Ref R/184/17/PD

Application for change of use of 51 Sea Lane from class A1 shop to class A3
Restaurants & Cafes.

**APPENDIX ONE:
DRAWING SHOWING EXTERNAL EXTRACT AND VENTILATION EQUIPMENT PROPOSED**

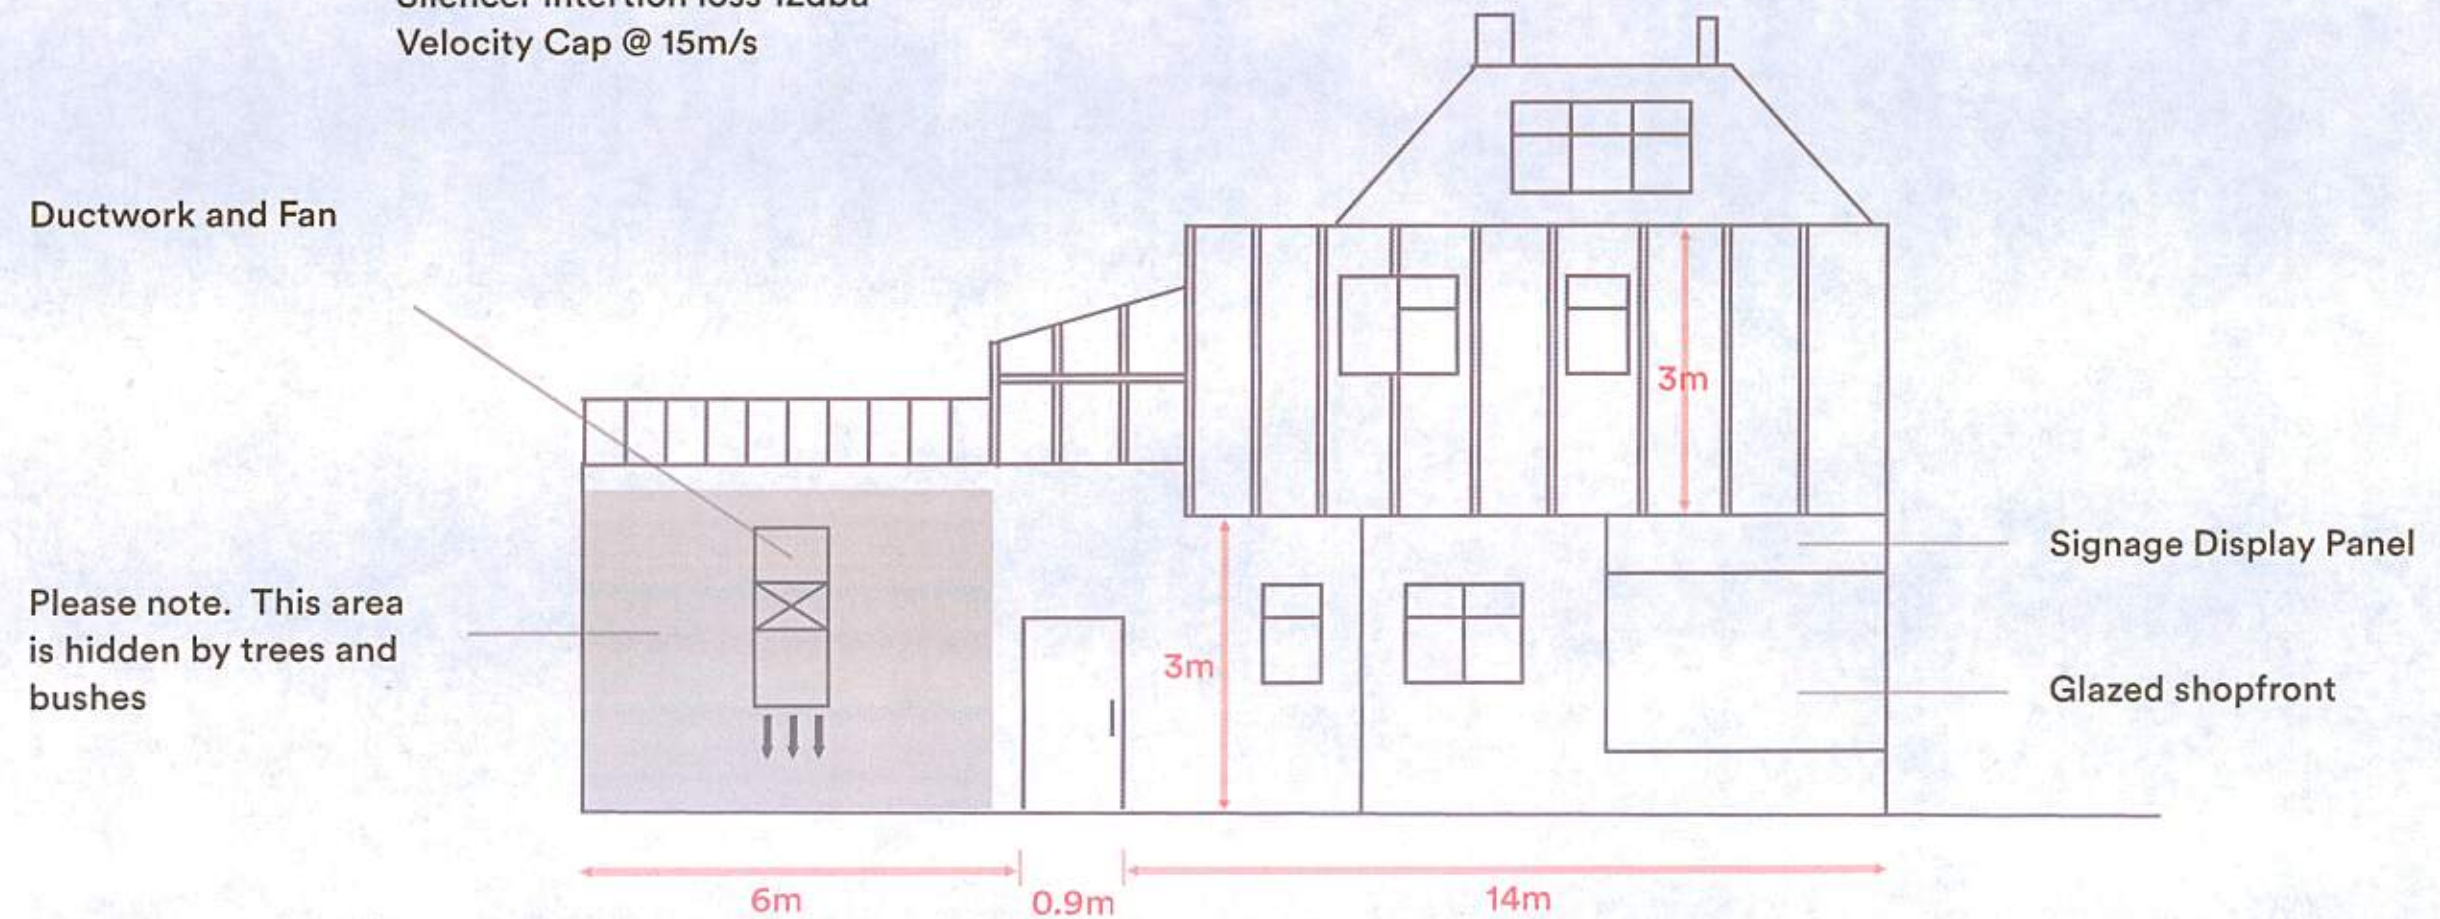
The positioning and use of a venting system for the proposed kitchens, which are according to the plans to be hidden by trees. Surely this then proposes a fire risk, particularly as the houses directly opposite the side entrance to number 51 is thatched. Secondly such a venting system would produce noxious odours and considerable noise.

APPENDIX TWO:
DRAWING SHOWING PROPOSED REFUSE FACILITIES

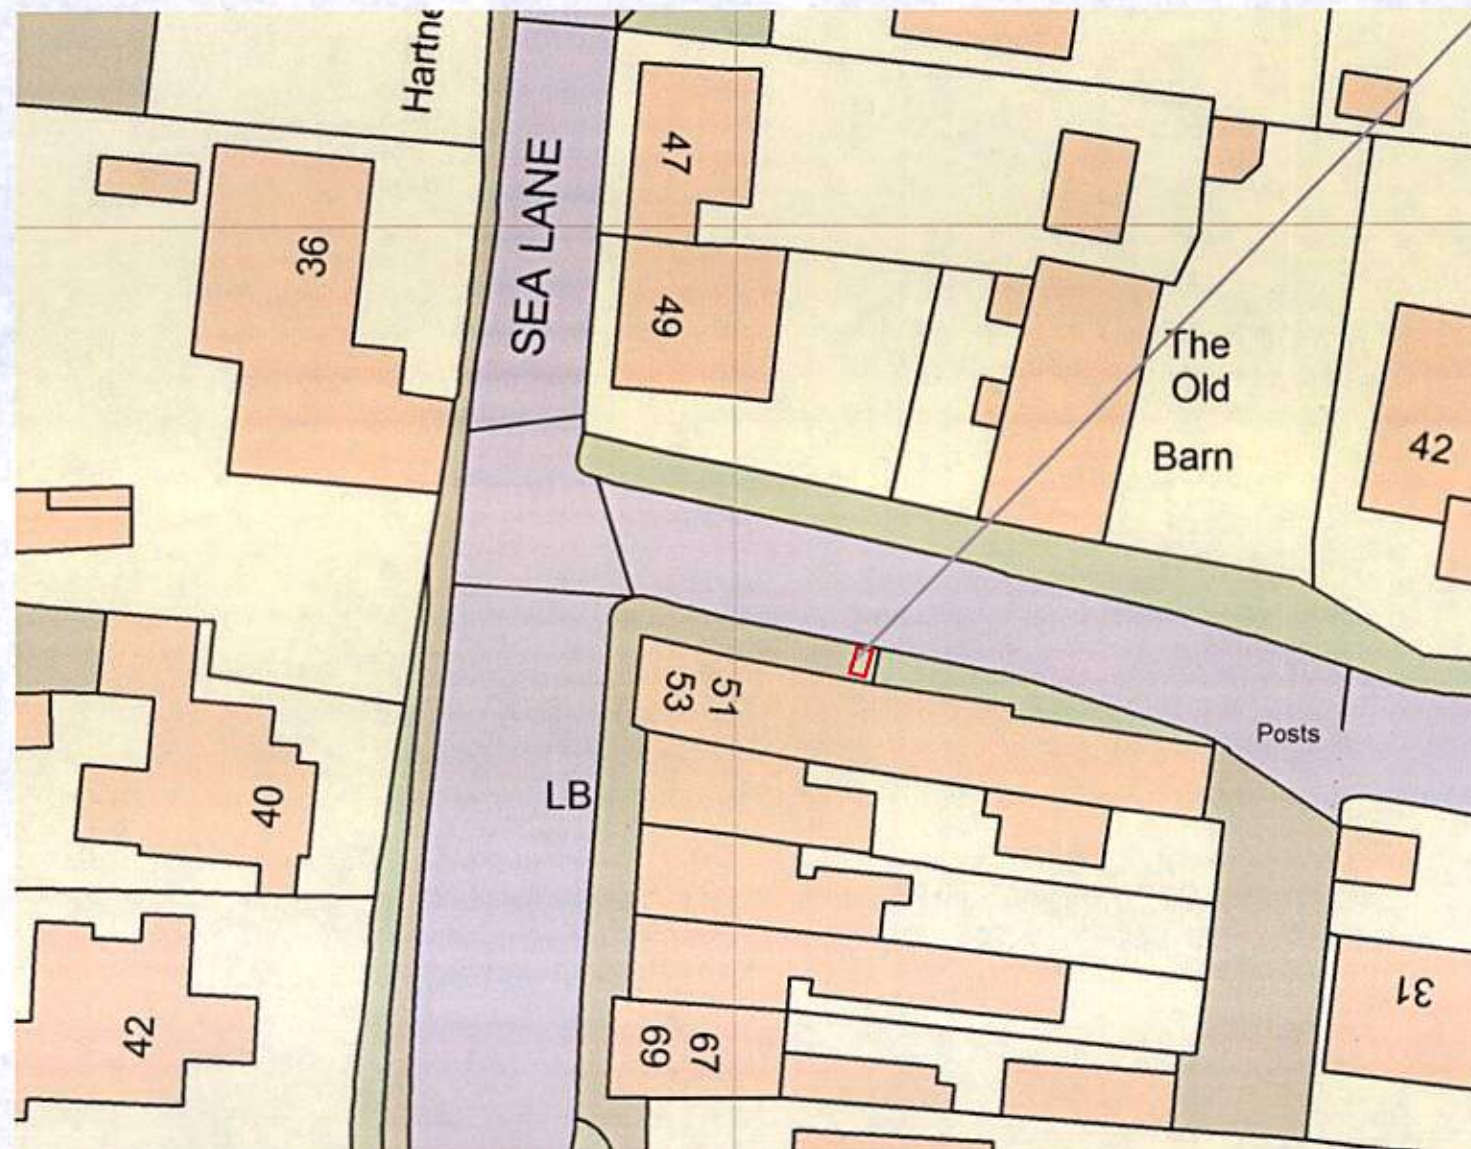
The potential for increased rubbish that will attract vermin and foxes with the attendant health concerns.
